A/109/20/RES

Land South of Water Lane Angmering

Approval of reserved matters following outline consent A/99/17/OUT for 175 No dwellings & associated infrastructure. This application may affect the setting of a listed building, may affect the character & appearance of the Angmering Conservation Area & falls within Strategic Site SD9, CIL Zone 1 (Zero Rated).

Sussex Village

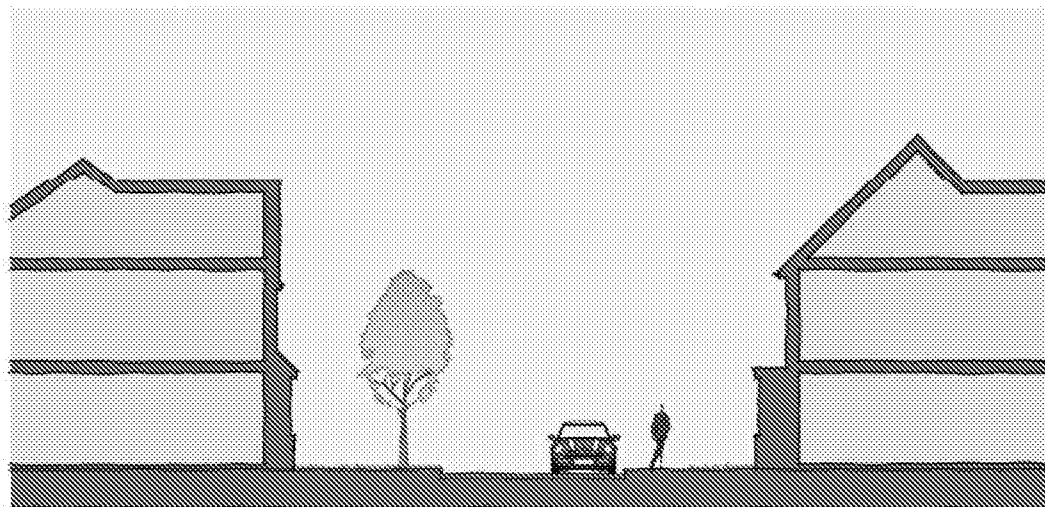
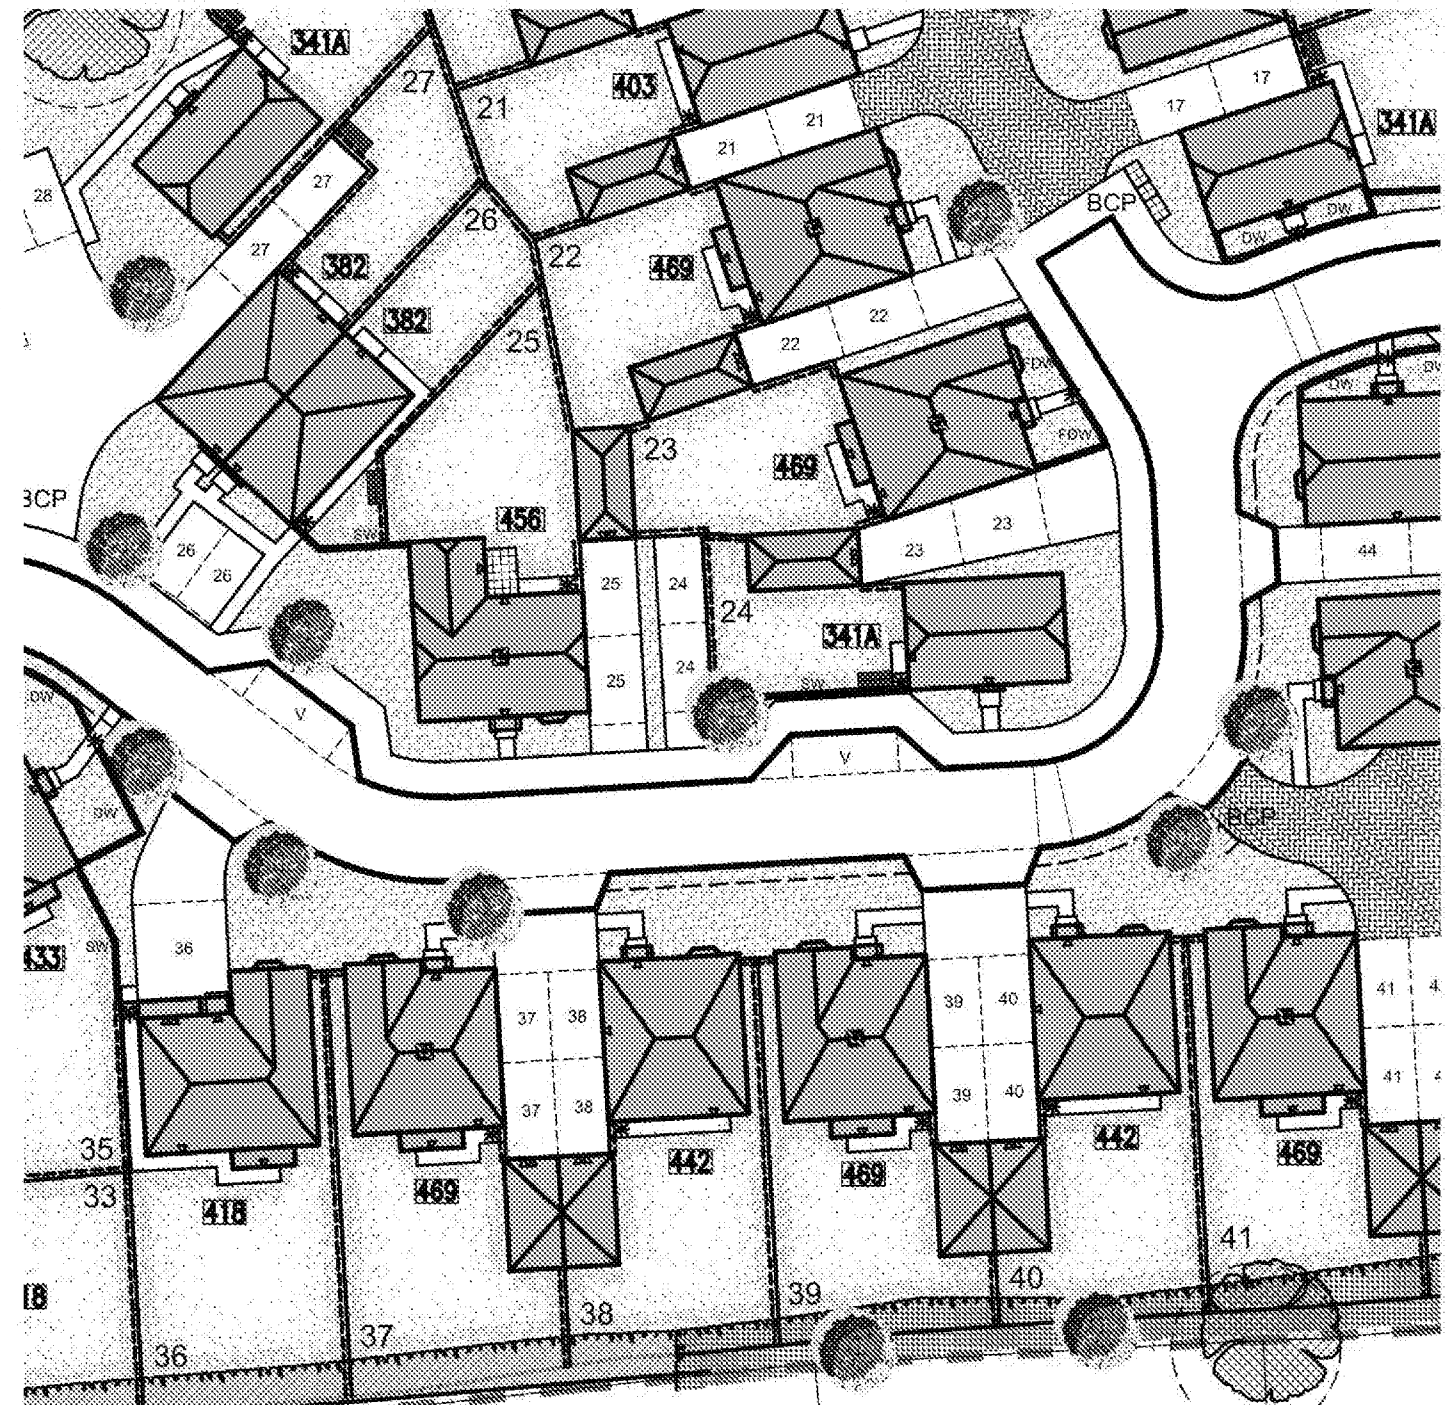
In addition, I also have concerns about the development in the western field. At present, it would appear that a good amount of the development would be visible from Weavers Hill, and therefore the conservation area. The development in this field, especially that closest to the conservation area appears to be formed of standard properties which would conflict with those found on the lane. Such a concept is harmful.
